PRELIMINARY/FINAL DRAINAGE REPORT

JUDGE ORR ROAD RV PARK & STORAGE DEVELOPMENT

ADP Project No.160301
May 18, 2018

PPR-16-040

M:\LAND PROJECTS\2016\160301-Existing Conditions.dwg Jim Gill Thu, 05/02/19 5:45 PM

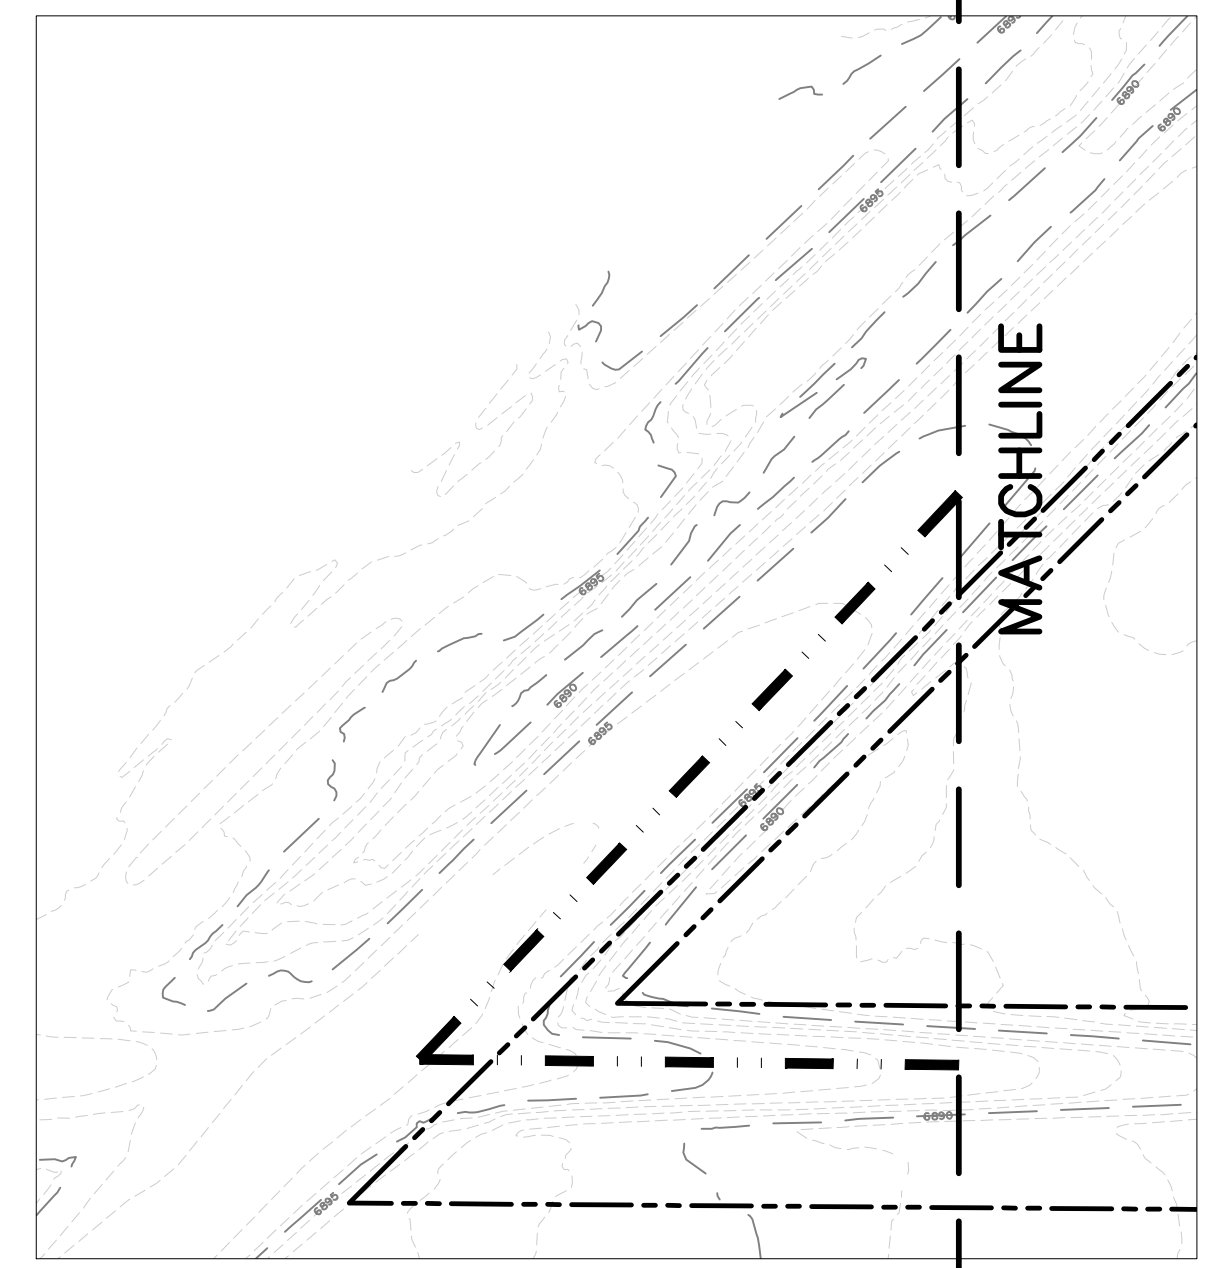
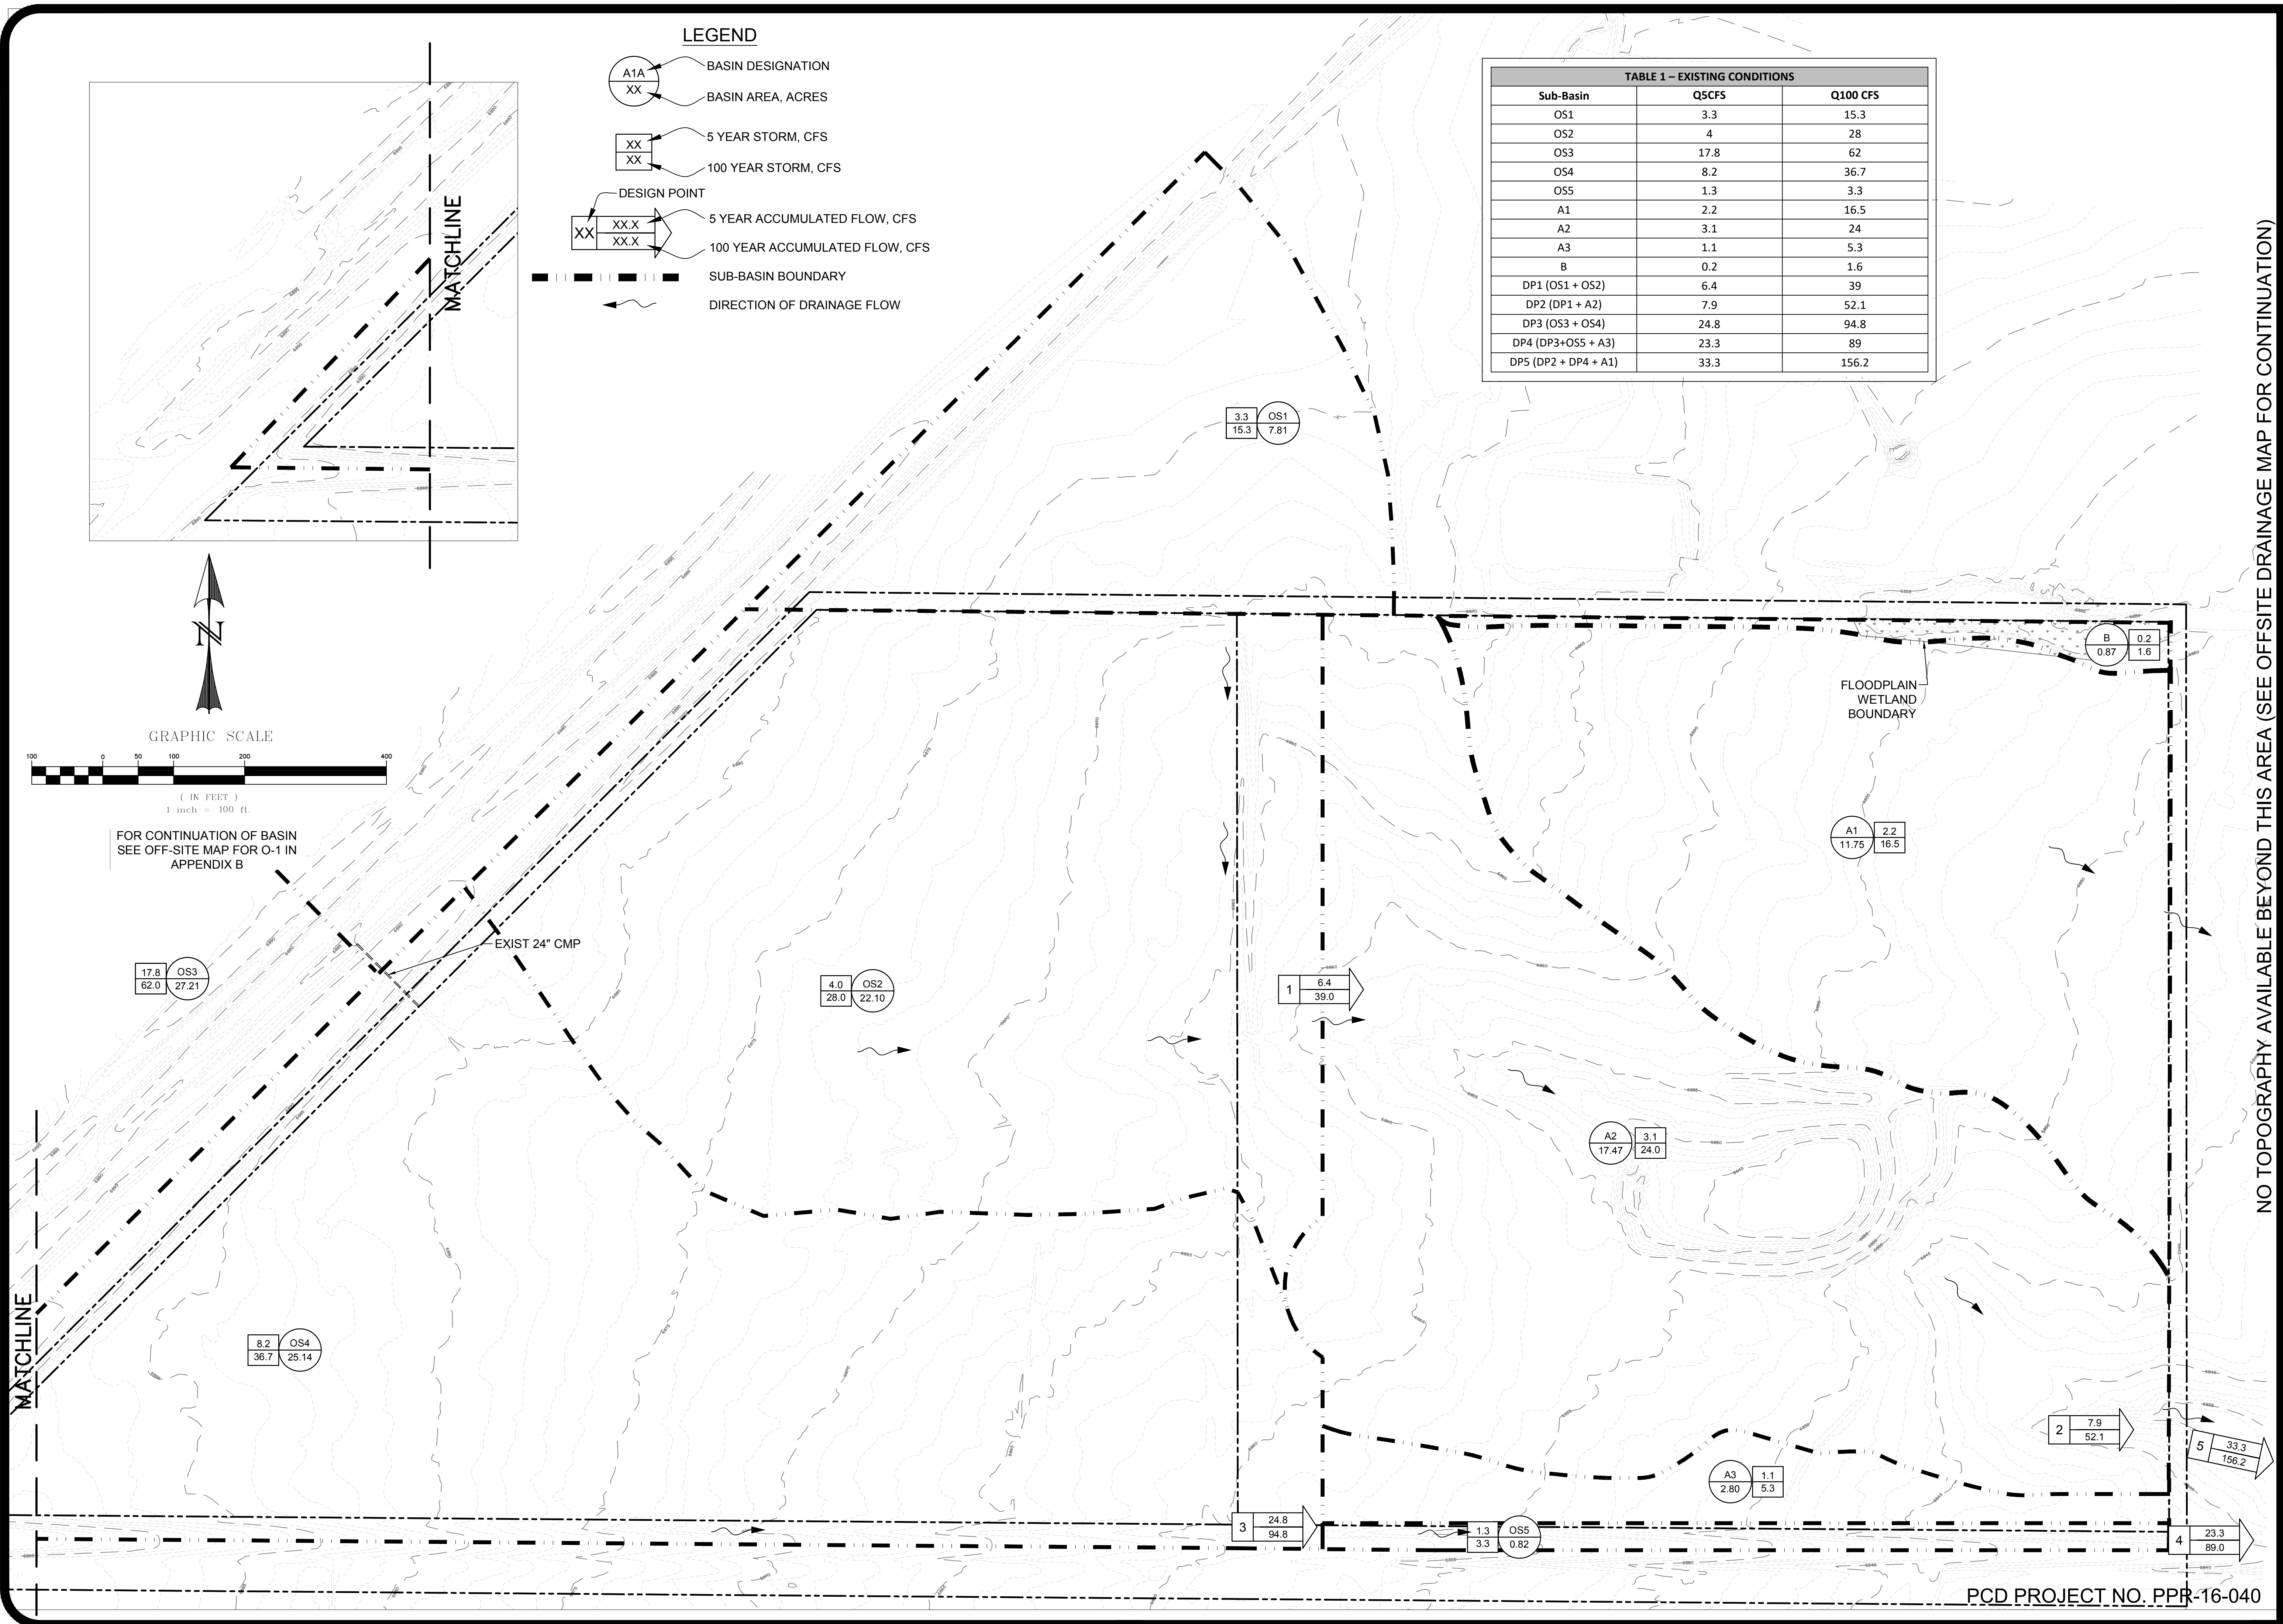
Revise the routing summary per comments on the summary table of the existing drainage map
